CITY OF ALBUQUERQUE

March 11, 2015

**RE: Array Technologies Paving
3901 Midway PL NE
Grading and Drainage Plan
Engineers Stamp Date 2/23/2015 (E17D034C)**

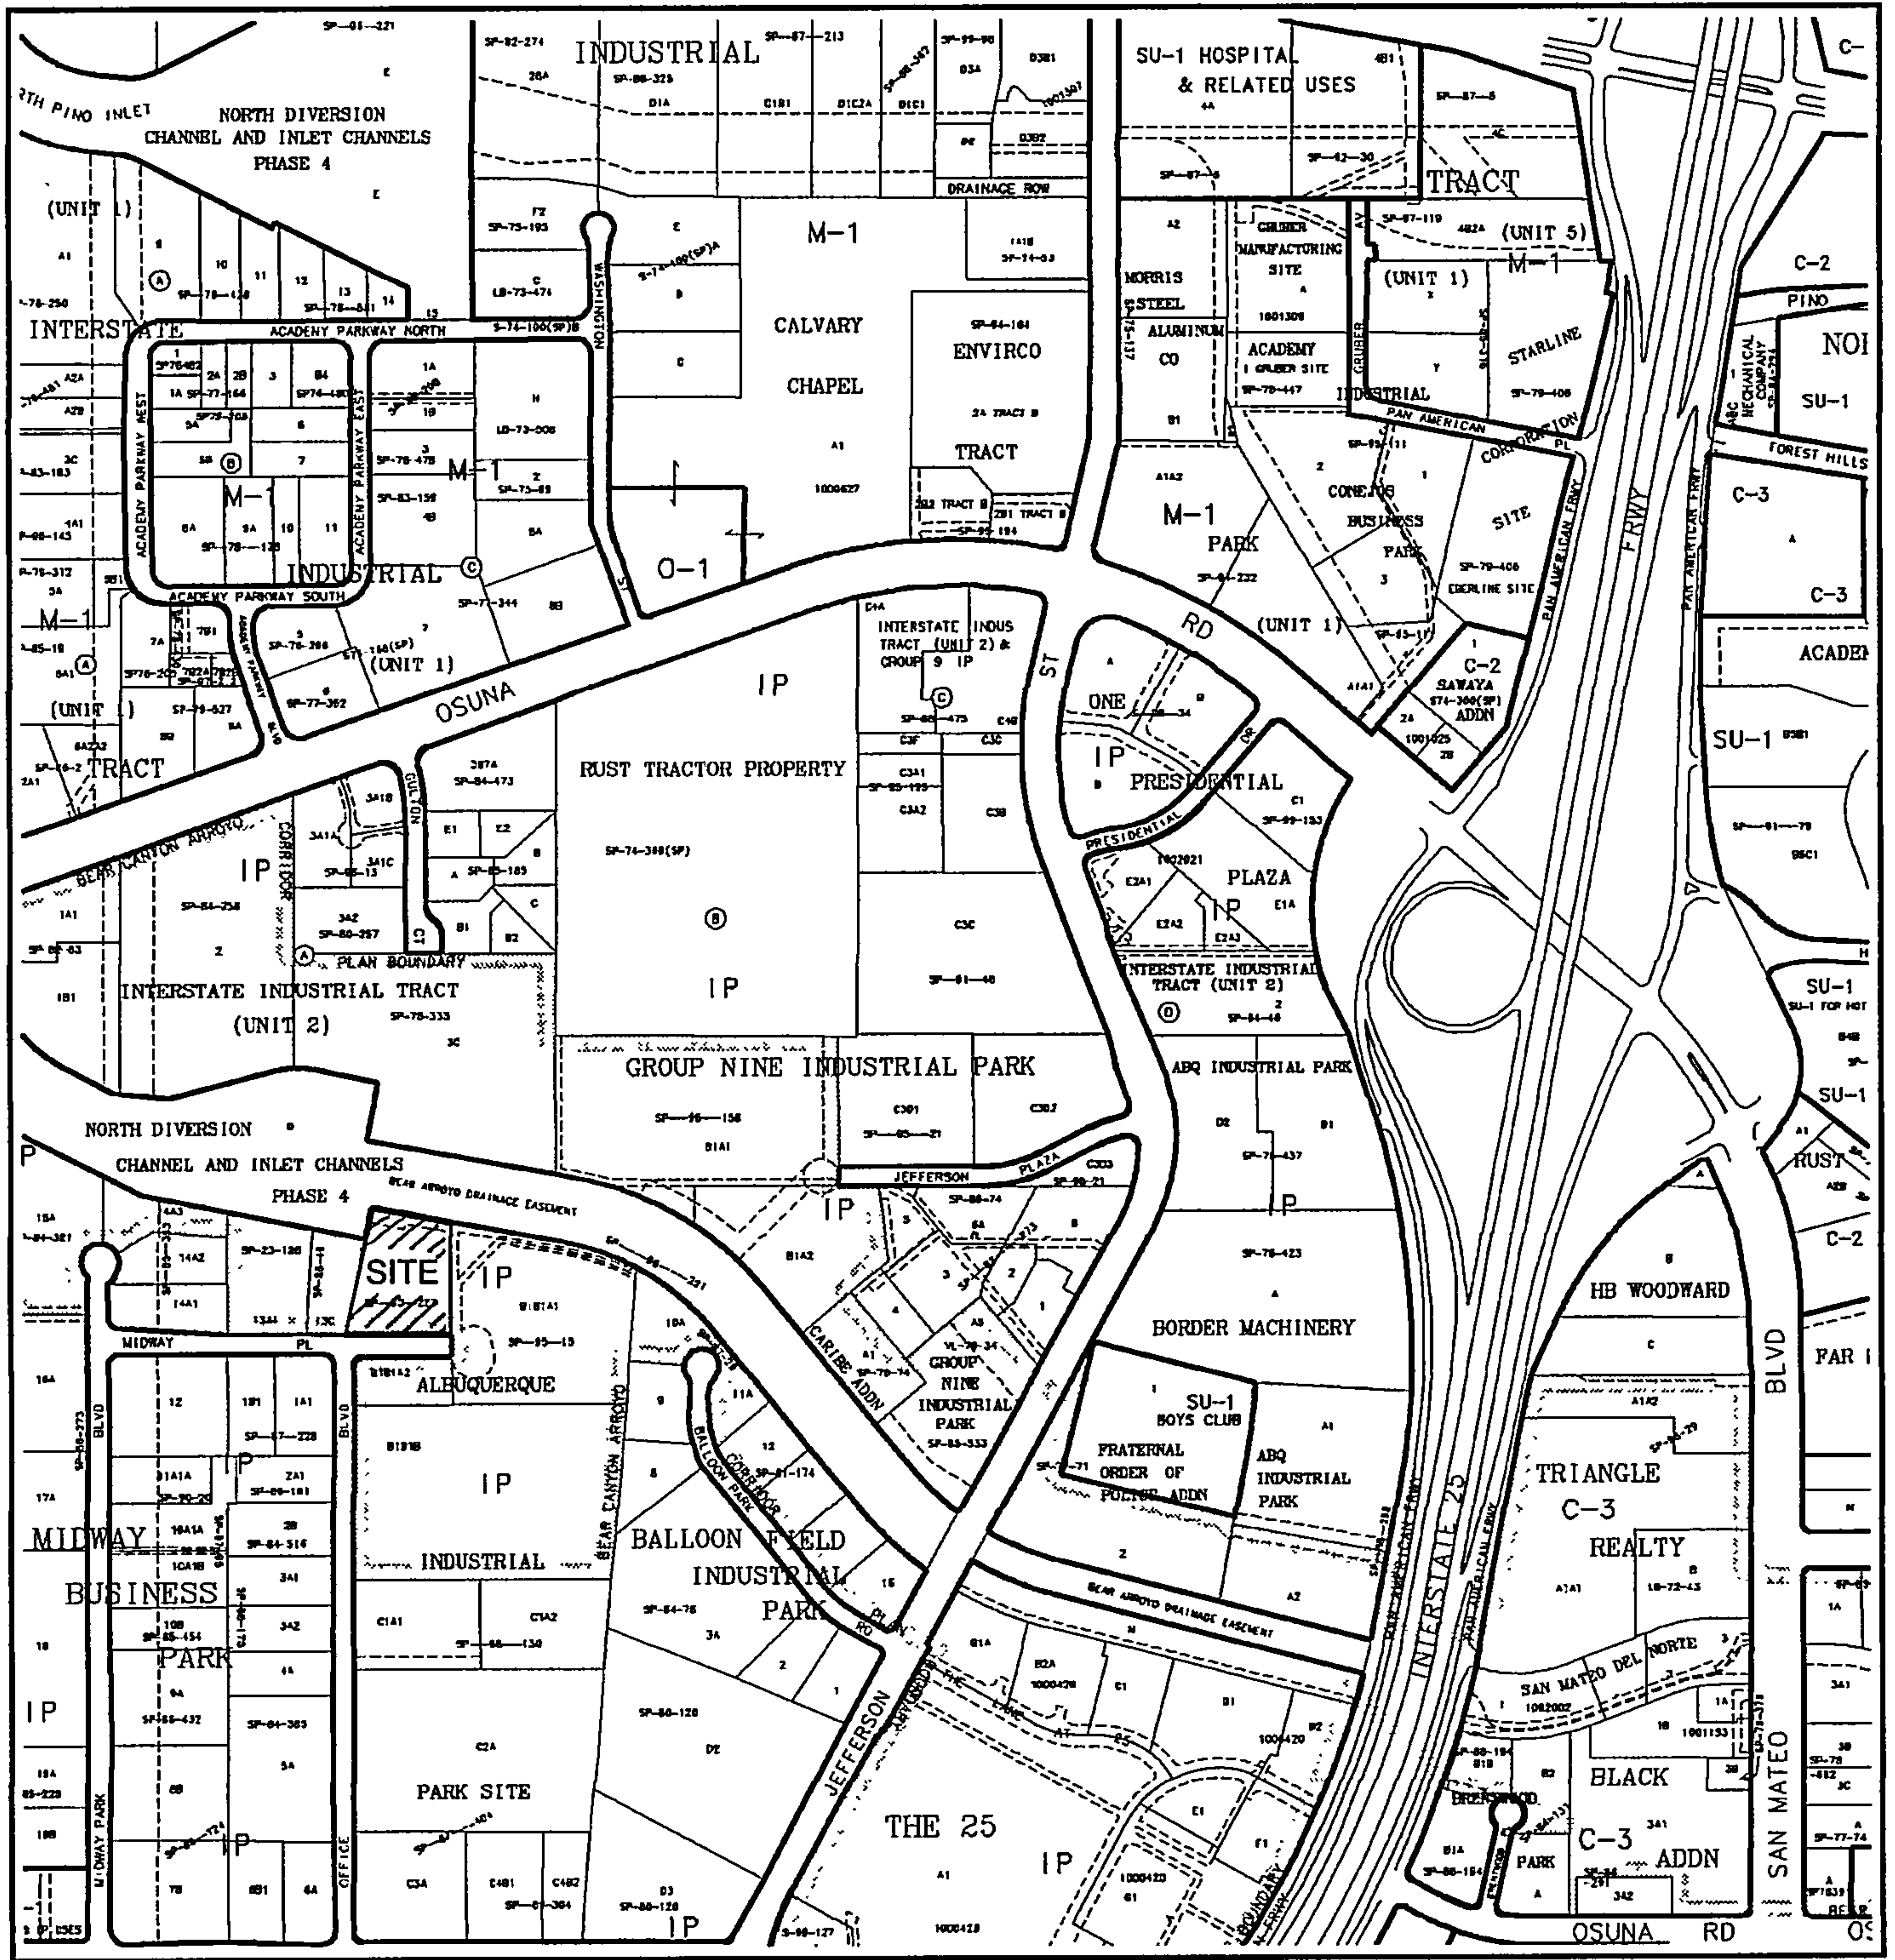
- Mention of the first flush per EPA standards is required and placed on the plans. The amount required for detention is .34" times the new impervious area. Depress the landscape islands/areas as part of the first flush requirements.
